Land at Stakers Farm, North End Road, Yapton, reference Y/72/20/RES
Proposals to vary condition 1. under Section 73 of the T&CPA 1990 (as amended by the Planning and Compulsory Purchase Act 2004):

The application is submitted to seek to amend Condition 1. of planning permission Y/72/20/RES. The condition as currently written stipulates:

Dandara seek to amend the condition to reflect plans detailing the layout, street scene and elevations for the following reasons;

JOB.NO	DRAWING.NO	REV
102-70	UPN+-E5-P5	C

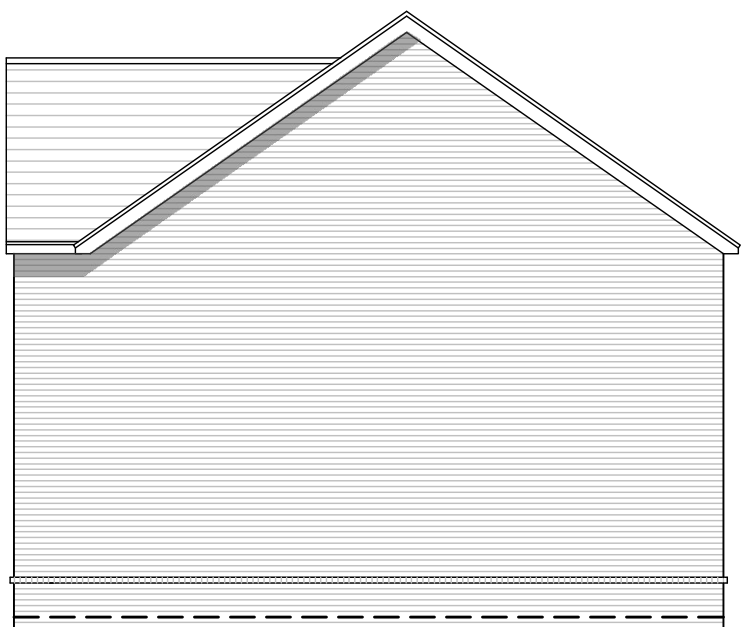
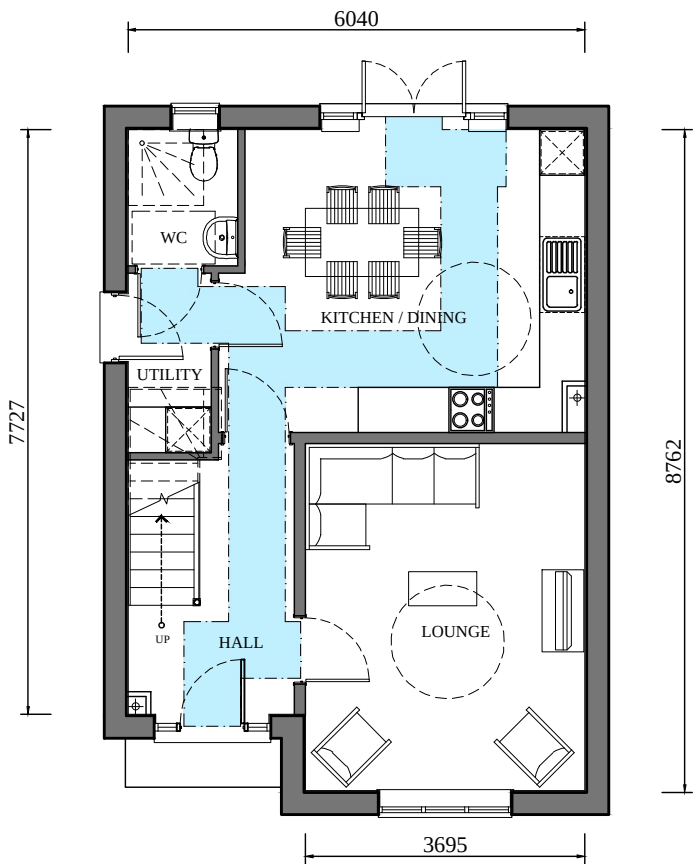
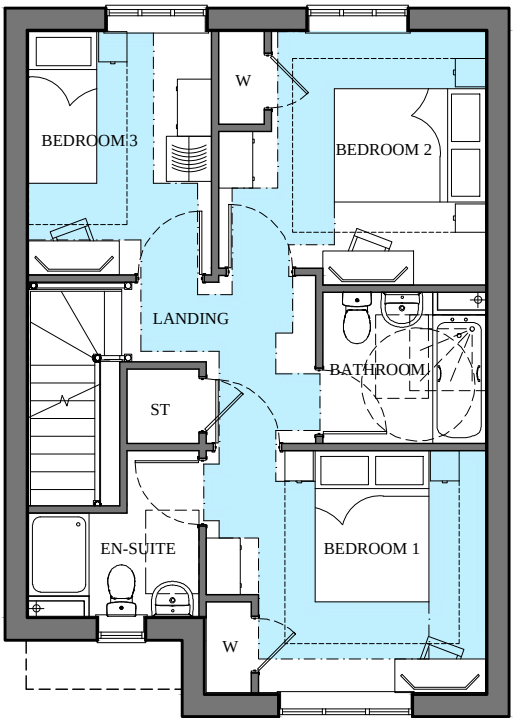
to satisfy these concerns, we are proposing to remove all 33 car ports across the site in addition to the removal of 15 linked roofs on our Upnor+ house type.

Whilst the accommodation within the linked roofs is being removed, the overall mix for the scheme is not changing and the Upnors are still in excess of the national describes standards required for a 3 bed 5 person dwelling, as well as being CATM4(2) compliant.

For clarity, Upnor+ plots; 1, 2, 7, 8, 9, 10, 11, 14, 15, 16, 20, 21, 26, 68 & 69 will be losing the additional accommodation following removal of the linked roofs.

REV	DESCRIPTION	DATE	AUTHOR	CHECKD
CLIENT				
PROJECT				
LAND AT NORTH END ROAD YAPTON				
DRAWING				
BOUNDARY TREATMENT LAYOUT 70 UNIT SCHEME				
SCALE	DATE	AUTHOR	CHECKED	
1:500 @ A1	02.08.19	LAH	-	
JOB NO	DRAWING NO	REV		
102-70	PL-07	F

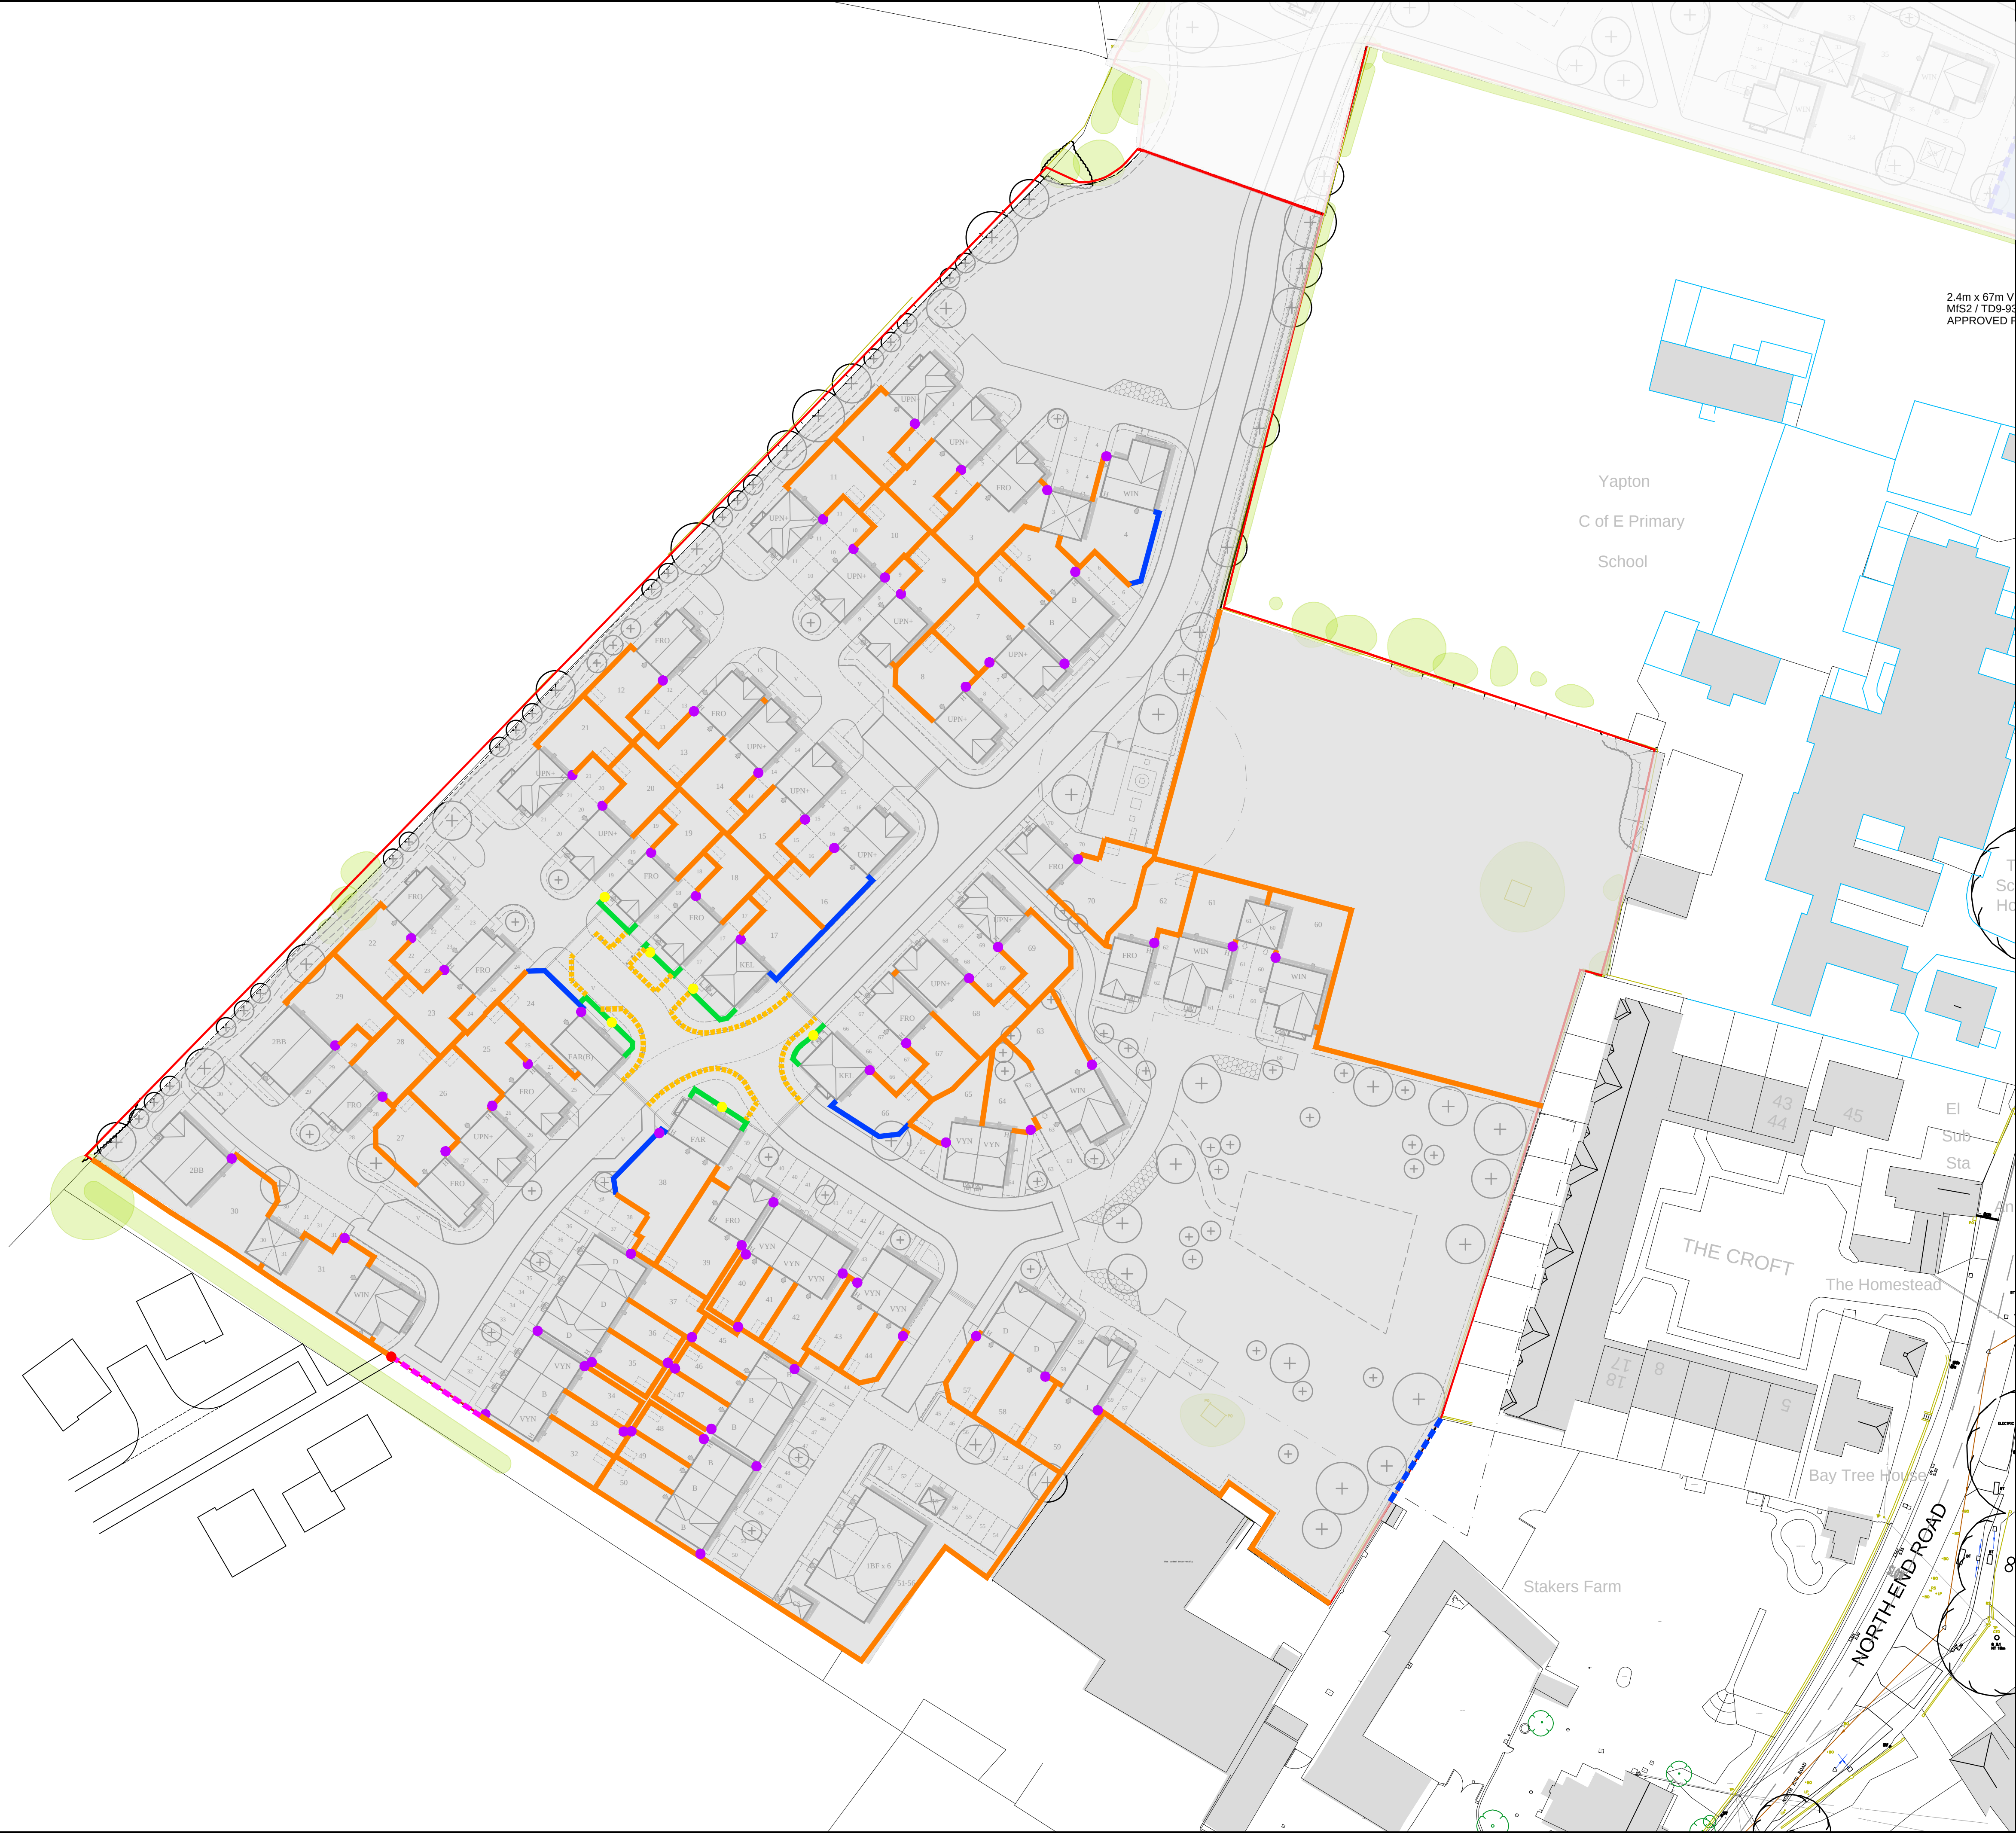
In addition, the approved scheme overprovides by 16.5 spaces against the policy requirement for parking. Dandara are proposing to remove 9 spaces across 3 bed properties where 3 parking spaces were being provided rather than the policy required 2. By doing so, there is an increase in private garden amenity space on the relevant plots and a reduction in hardstanding areas requiring drainage.

For clarity, plots; 7, 8, 26, 27, 28, 38, 39, 62 & 70 will be changing from 3 spaces to 2.
